Engineers Comments Regarding Surface Water Drainage

Application Reference:	AL/68/26/DOC	Reviewer Reference:	ADC/EXT5/AF
Planning Officer:	Hebe Smith	Date of Review:	24/08/2026
Site Name:	Land West Of Ryefield Farmhouse Oak Tree Lane Woodgate PO20 3GU		
Application Description:	Approval of details reserved by condition under AL/31/22/PL relating to Condition 5- Proposed Surface Water Drainage Scheme, Condition 6- Drainage Discharge and Condition 7- Maintenance & Management of Surface Water Drainage Scheme.		
Assessment Number:	1

Application Reference: AL/68/26/DOC Site Name: Land West Of Ryefield Farmhouse Oak Tree Lane Woodgate PO20 3GU	Initial Issue Date: 24/08/2026 Issue Date: 24/08/2026 Reviewer Reference: ADC/EXT5/AF
---	---

Drawing Title: Engineering GA - Levels & Drainage

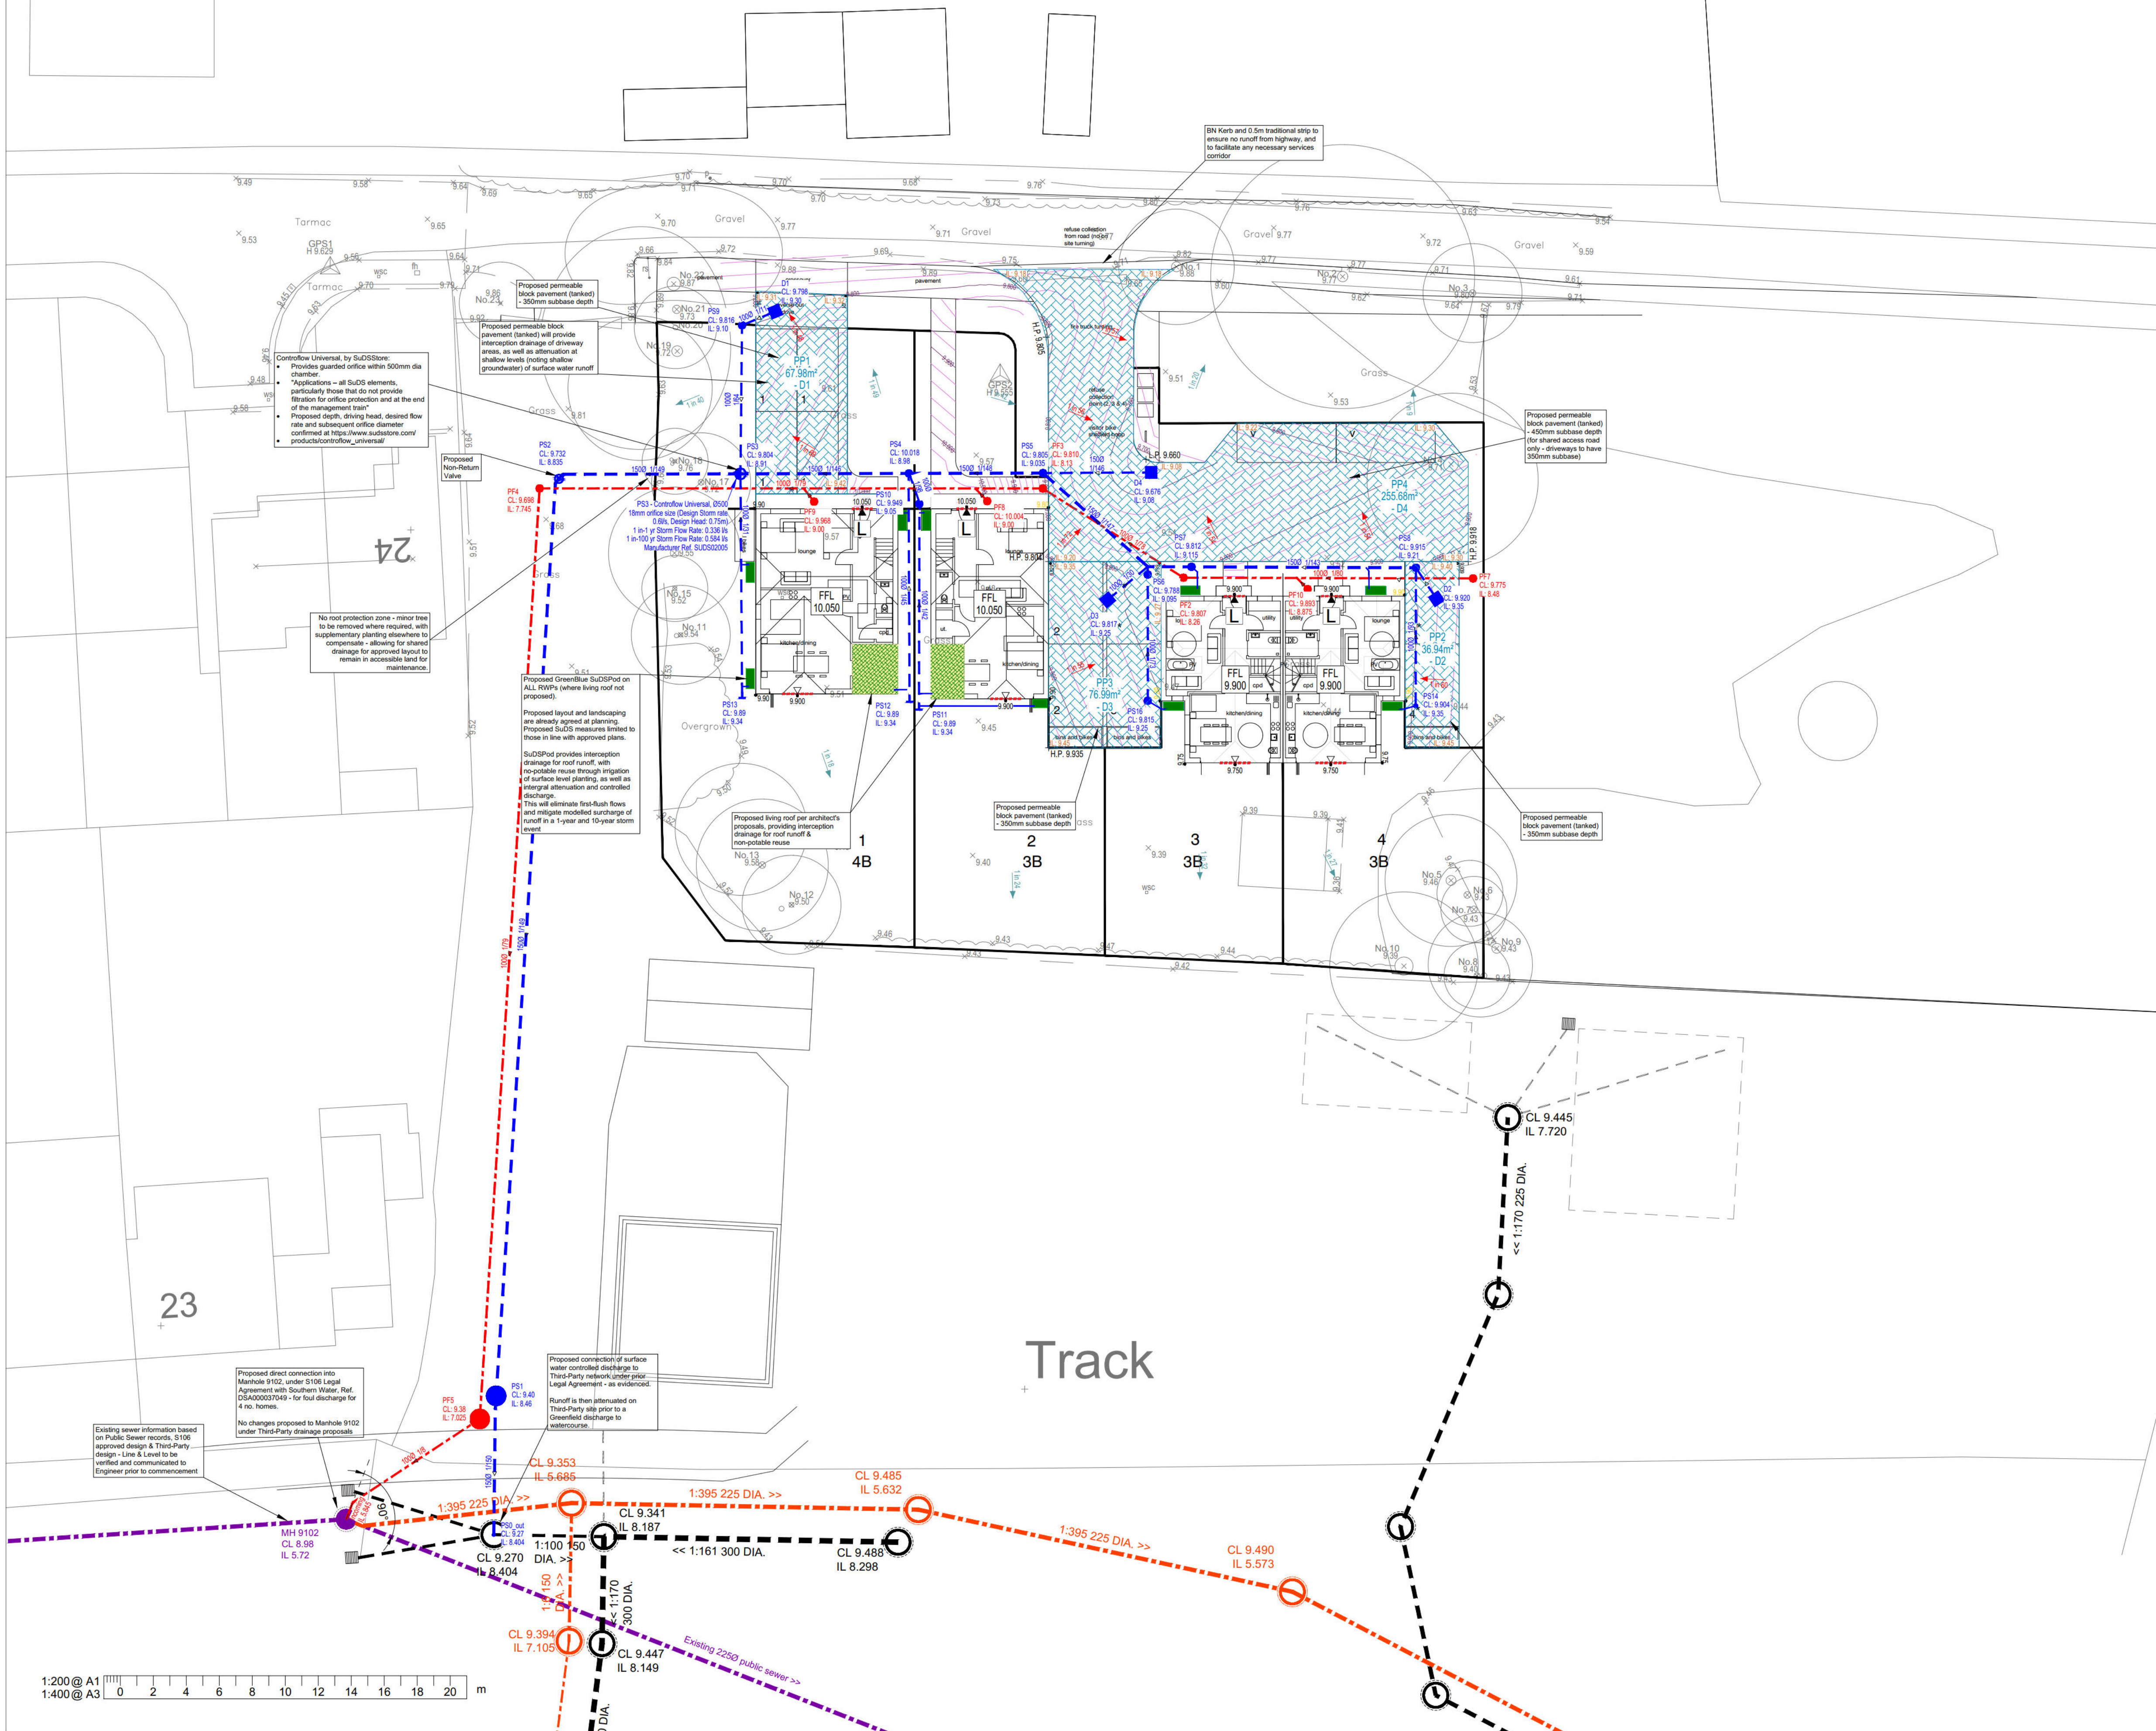
1. Please see the attached comment tracker for detailed comments relating to the submission.
2. We note the previous (refused) application AL/38/26/PL and our previous comments, which are replicated on the comments tracker for continuity.
3. The latest drainage layout indicates discharge to the neighbouring site's drainage system (as proposed at planning stage) at a different point of discharge to the planning stage strategy and would be acceptable in principle subject to further information.

Comment Number					
1.	The drainage strategy proposed at planning stage has not been developed to a technical design. The proposed revised design is not in accordance with national and local sustainable drainage policy which specifically precludes discharge to a foul water sewer. It was made clear in comments at full planning stage that a proposed connection to the foul water sewer would not be acceptable. Designer Response 08/07/2026 The drainage strategy has been revised to follow the principles of the strategy referred to adjacent	The proposed 'temporary' connection to the foul water sewer is not in accordance with national sustainable drainage policy and is not acceptable. There is no guarantee the situation would be temporary and no provision in the planning consent to enforce an alternative solution after a certain period. If the planning strategy is not feasible or not yet available an alternate strategy would need to be developed.	The revised drainage layout shows discharge to the drainage system at the site to the south in accordance with the planning stage strategy. There is an easement deed which confirms rights to discharge. The point of discharge is different to the planning stage strategy. The applicant should provide information on the downstream infrastructure and outlet for the new point of discharge and demonstrate the change in location does not increase flood risk at the neighbouring development.

2.	The technical design will need to be reviewed once the method of disposal of surface water drainage and the point of discharge is in accordance with the planning stage drainage strategy, or an alternate strategy is proposed which is in accordance with current sustainable drainage policy and standards Designer Response 08/07/2026 N/A	Repeat comment: The technical design will need to be reviewed once the method of disposal of surface water drainage and the point of discharge is in accordance with the planning stage drainage strategy, or an alternate strategy is proposed which is in accordance with current sustainable drainage policy and standards. Designer Response 27/07/2026 No technical comments provided so no other updated.	The greenfield runoff rate calculation does not appear to be based upon the drained area. A pro-rata rate should be applied. The design peak flow should be checked against the pro-rata greenfield runoff rate and design rationale provided to confirm compliance with Standard 3 of the National Standards for SuDS.

implemented and operational prior to use. Currently the submission to discharge condition 5 does not shown a connection to the adjacent developments system but is not acceptable, see comments above. Clarification is required. Designer Response 08/07/2026 Designer understands that discussion with the planning authority has confirmed that a temporary connection to the foul sewer in accordance with the approved S106 will be acceptable, until the Third-Party infrastructure is in place (expected 2027). The revised design shows allowance for the temporary connection via a backdrop to PF5, to be removed upon implementation of the permanent solution	accordance with sustainable drainage policy. Designer Response 27/07/2026 No temporary connection to foul sewer proposed in update.

– with connection into the Third-Party infrastructure.	Designer Response 27/07/2026 Temporary option removed on advice of applicant, as Third Party infrastructure is being progressed. Design in full accordance with strategy proposed at planning & in accordance with national & local policy
